To: Planning < planning@oxford.gov.uk > Subject: Objection to 20/00934/FUL

I wish to object the planning application 20/00934/FUL (Land to the rear of The George Inn, 5 Sandford Rd, Oxford, OX4 4PU)

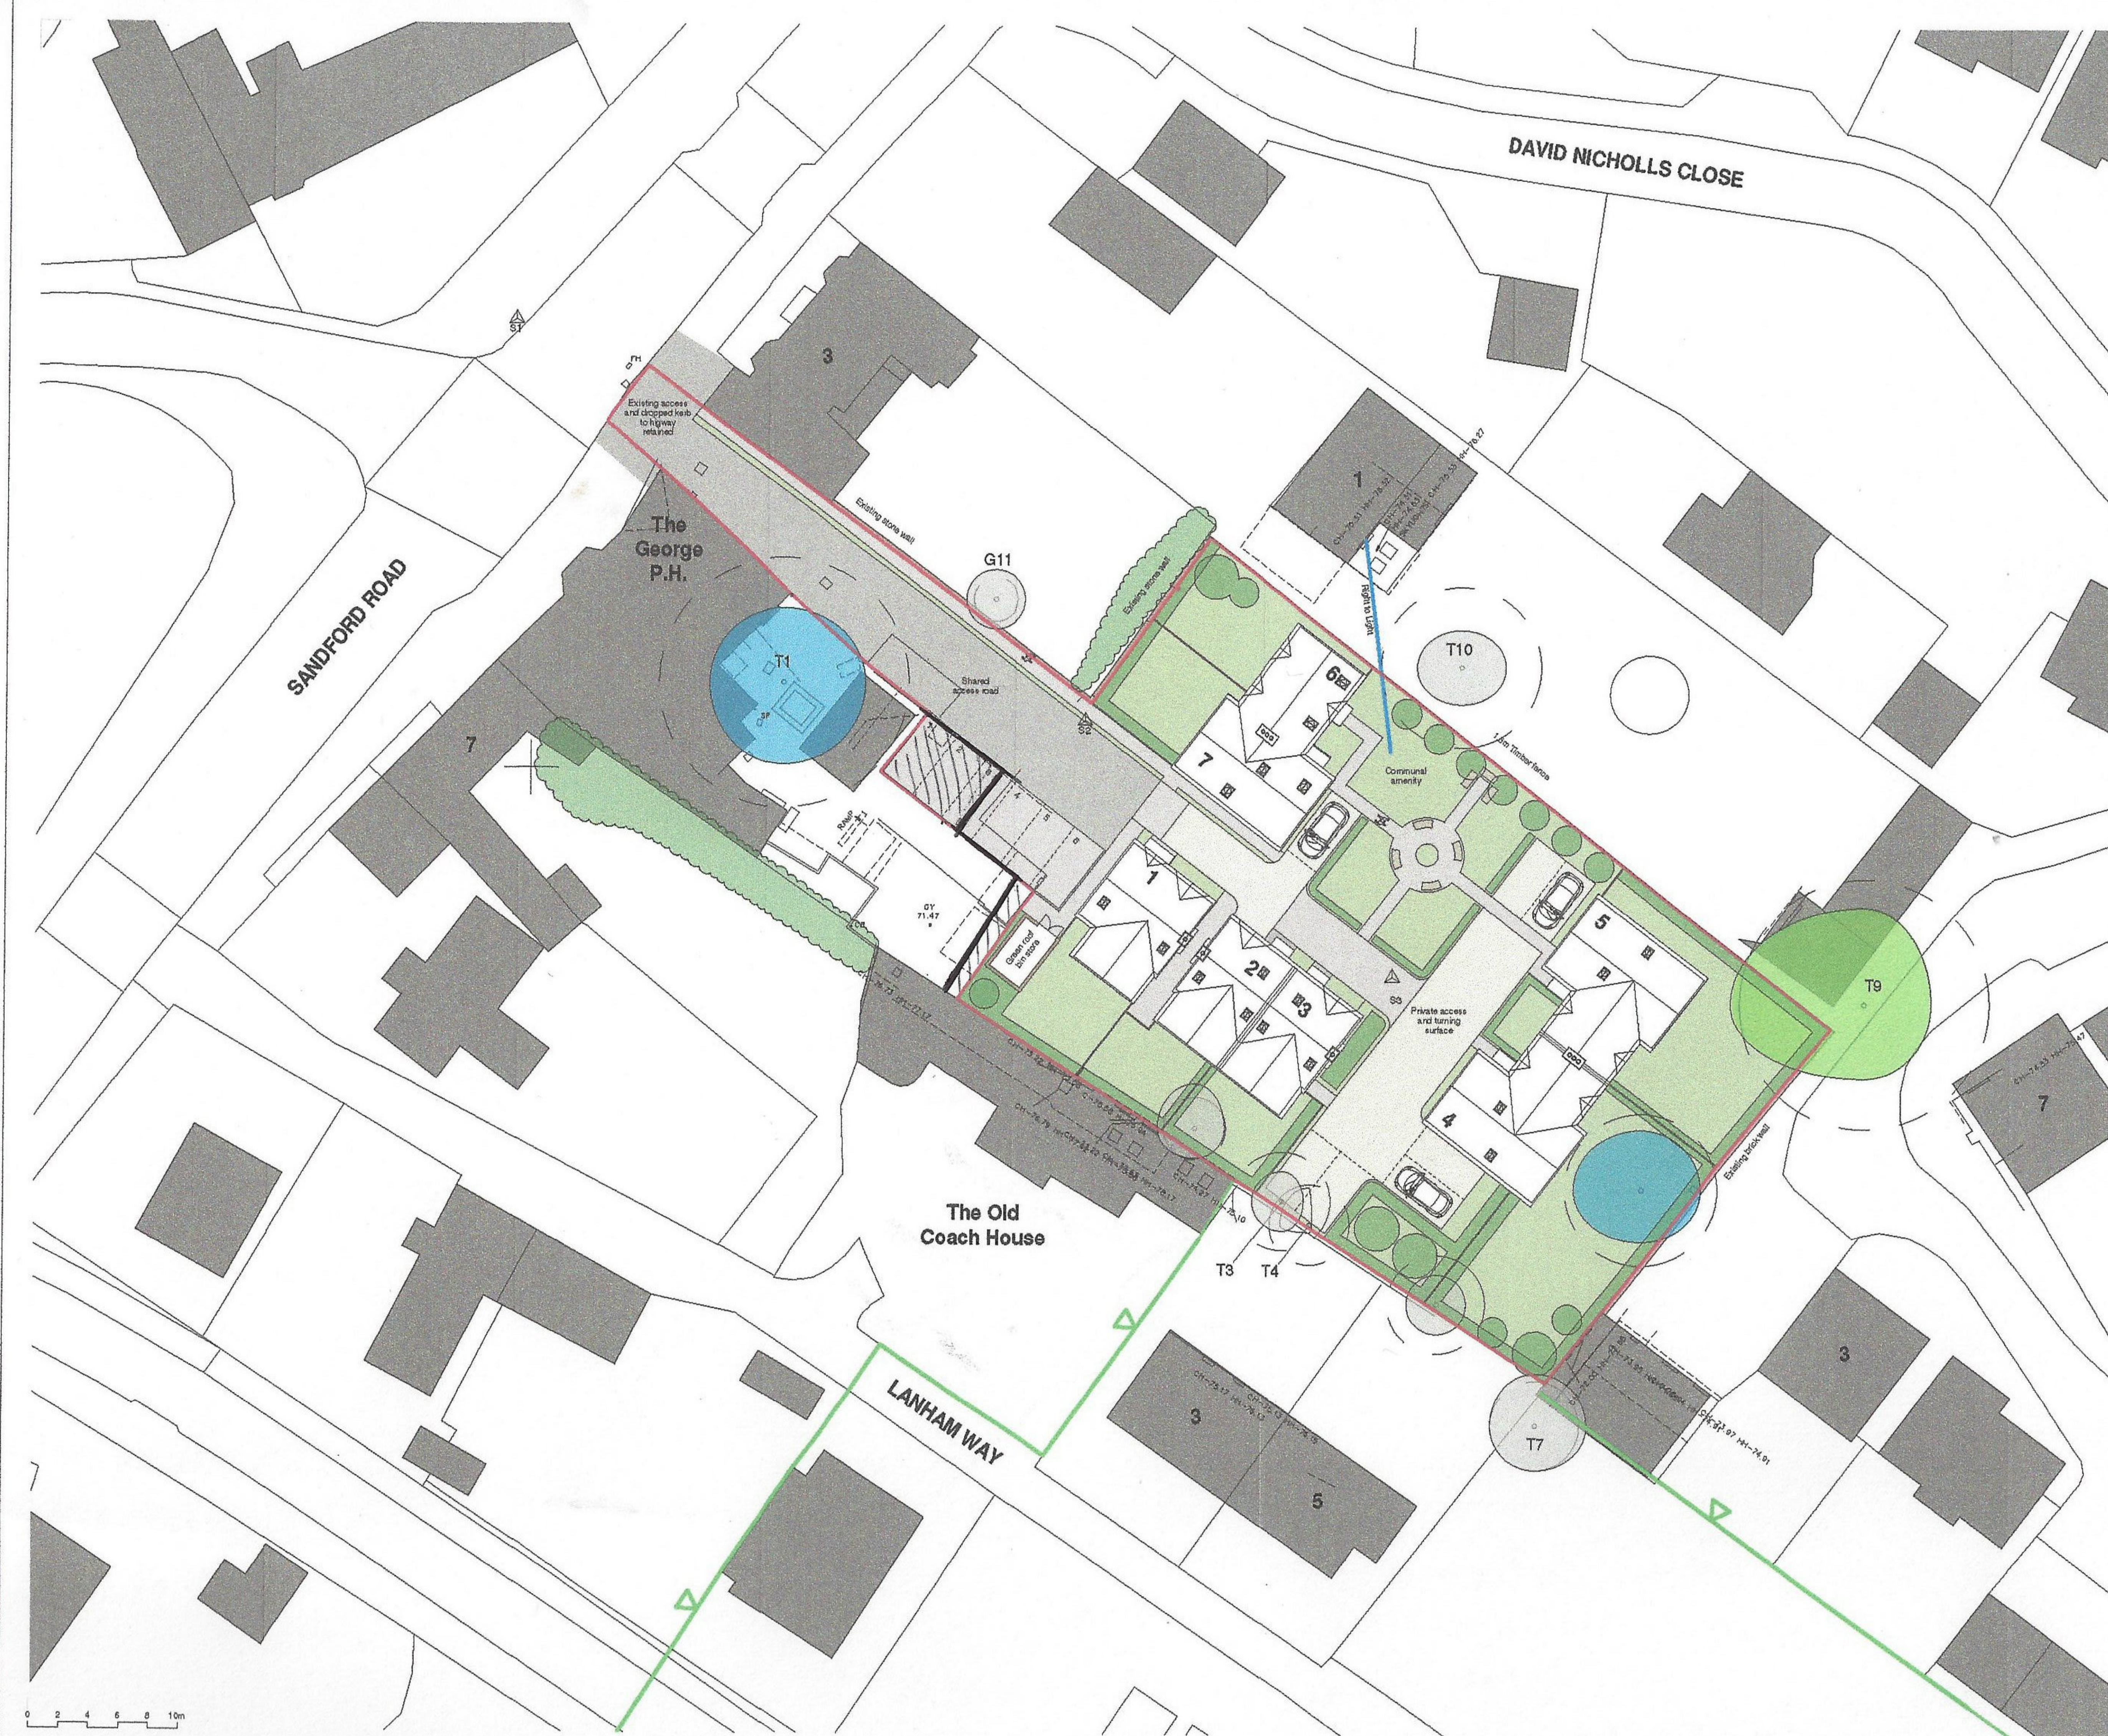
In response to the revised drawings of the proposed site plan submitted on 3/6/20 that have been submitted please note that this does not address any of my original objection as not all of the land is in the applicants ownership. It is shown that bin collection and storage and some of the parking is on my land which I am not prepared to accommodate therefore the application will be unimplementable.

I am the owner of the pub and as you can see from the plans attached which are the applicants proposed plan and the land registry plan showing ownership, it is clear that the applicant has sited their bin store and storage on land that is not in their ownership.

Also they show 5 of the 7 spaces for the pub encroaching on my land into my beer garden which also effects my smoking shelter. They have no permission to do this from me and I have no intention of implementing this parking scheme.
